Notification of Change to Proposed Development Subject to a Planning Appeal

Planning Appeal Reference: APP/C3105/W/23/3327213

Planning Application Reference: 22/02866/OUT

Land East of Ploughley Road, Ambrosden, OX25 2AD

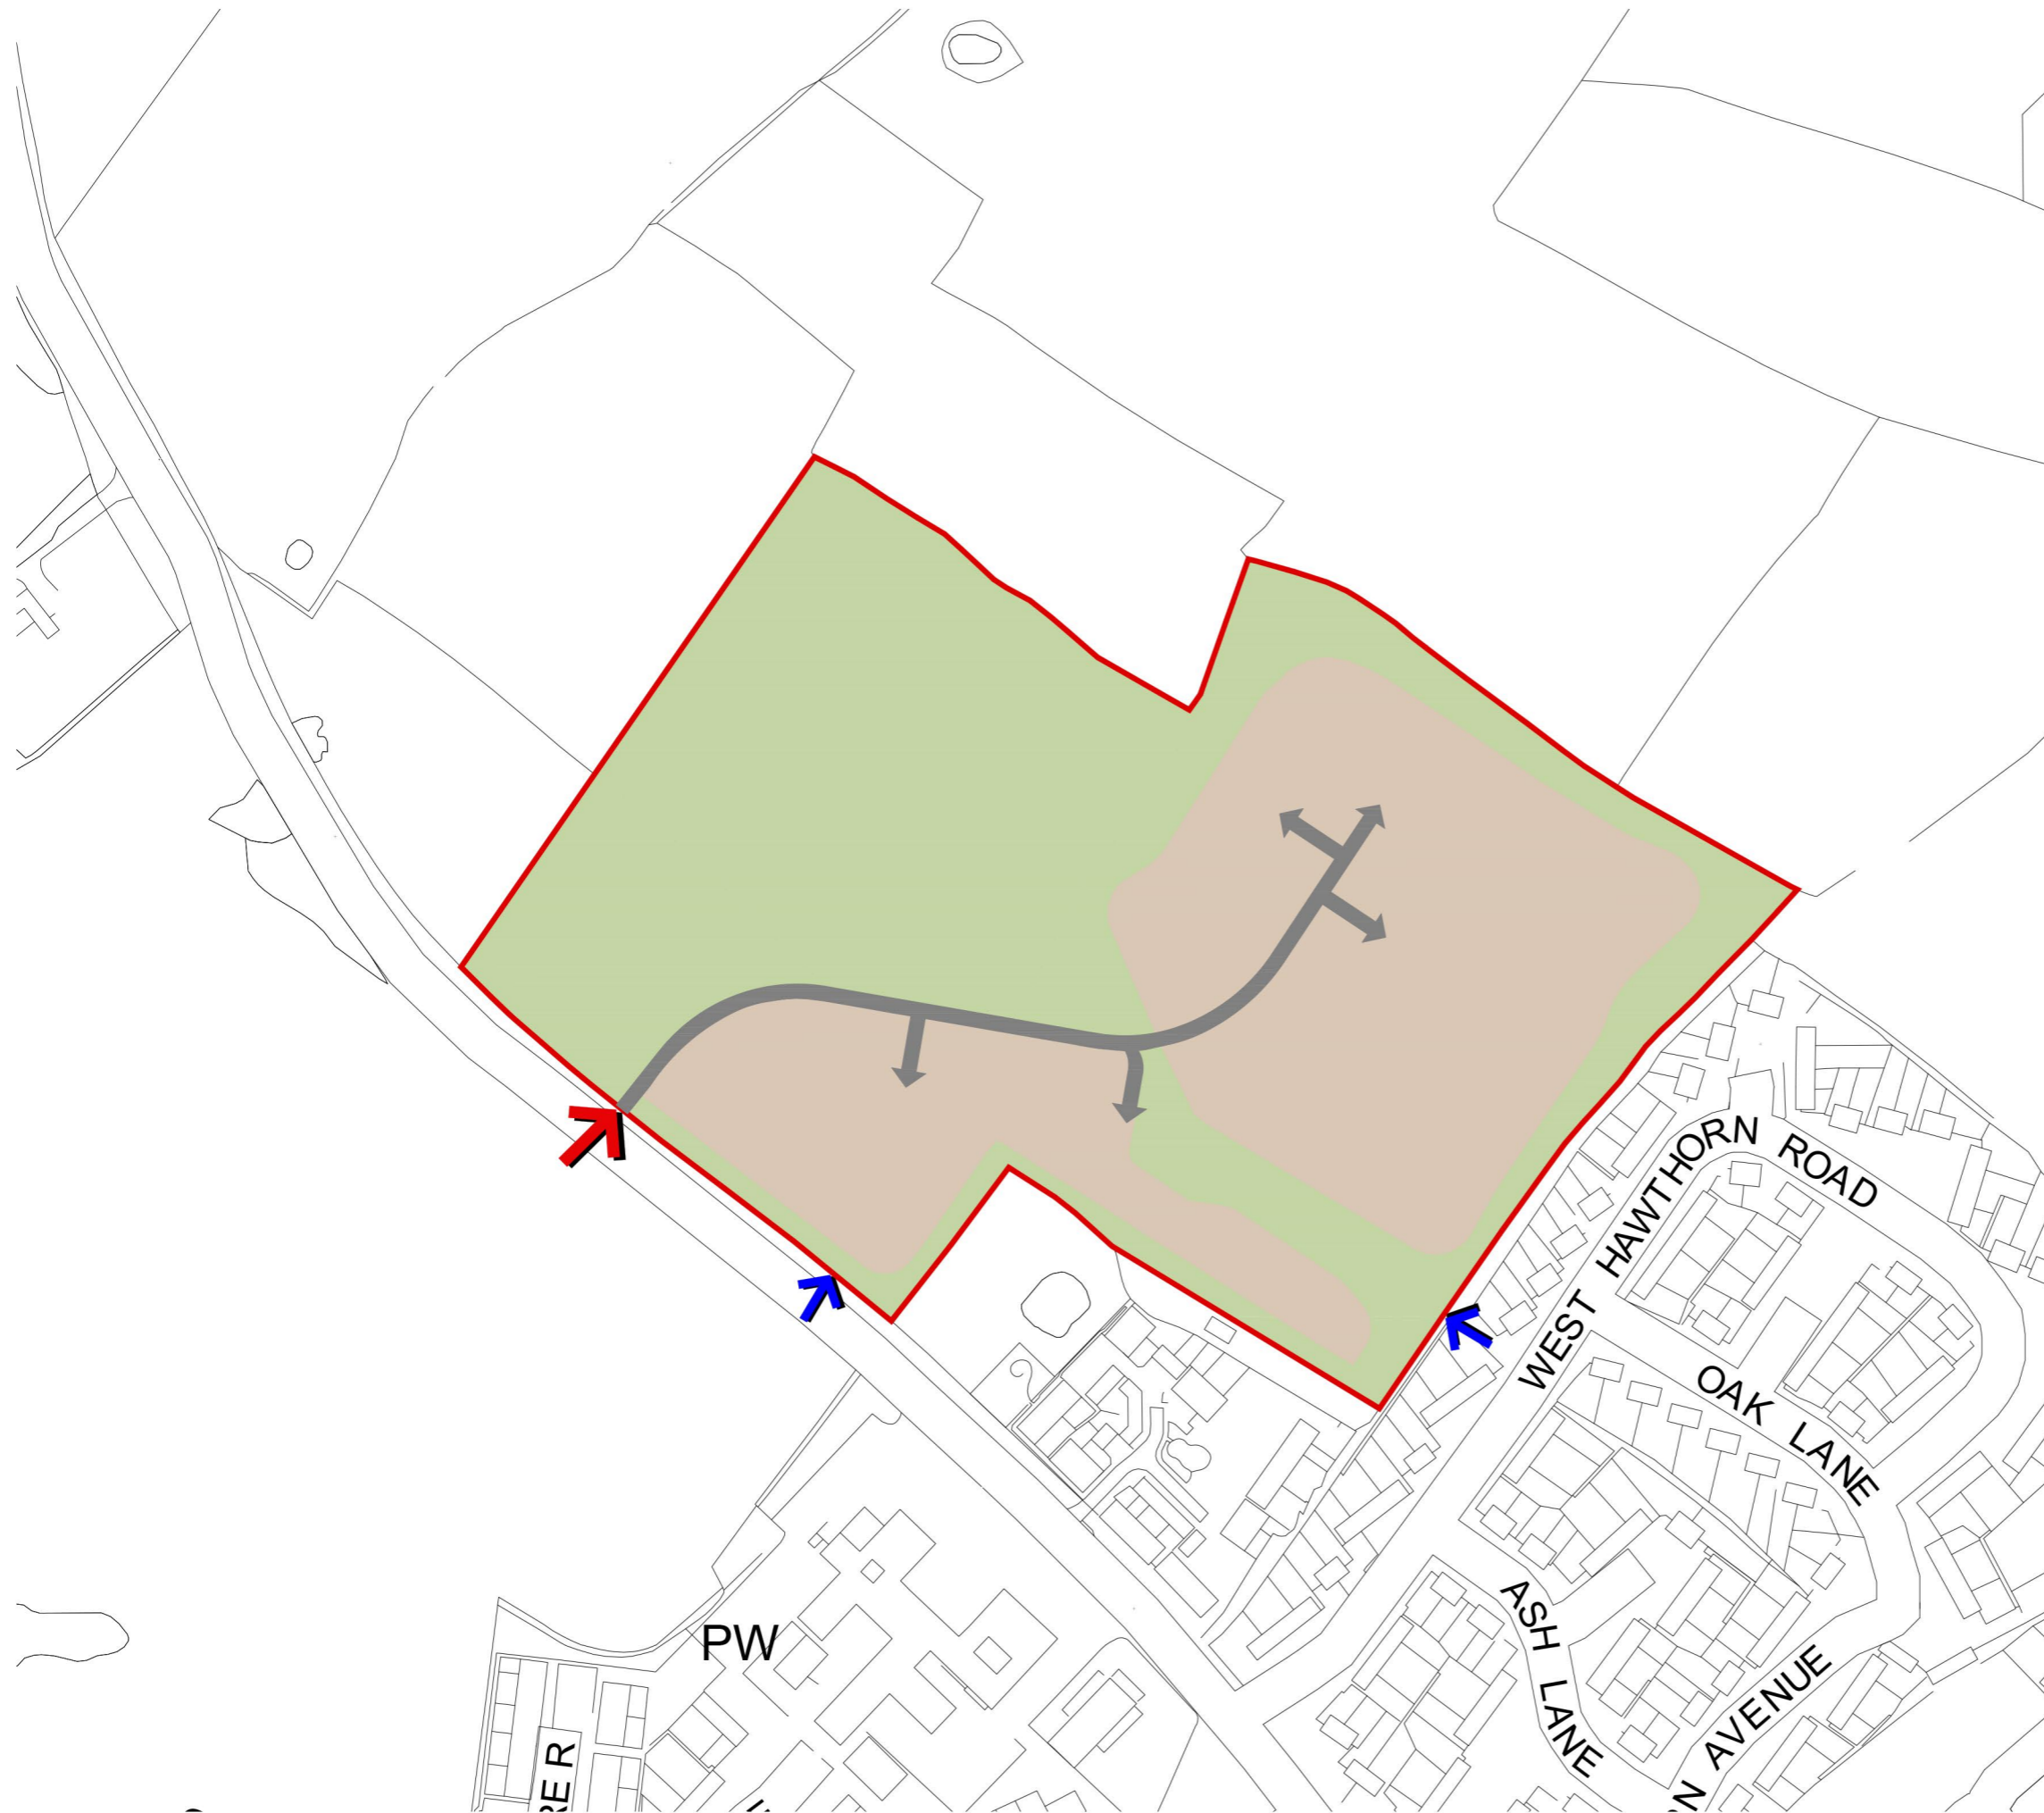
The proposed omission of a new pedestrian access to West Hawthorn Road has resulted in a change to the following 2 no. plans:

- Framework Plan, drawing number: FP-01 revision B (replacing previous version revision A)
- Parameter Plan Access, drawing number: 9603 revision B (replacing previous version revision A)

The proposed change is to omit reference to a new pedestrian access to West Hawthorn Road. The reason for this is to provide clarity that this is no longer the intention. A proposed pedestrian access to Ploughley Road will remain.
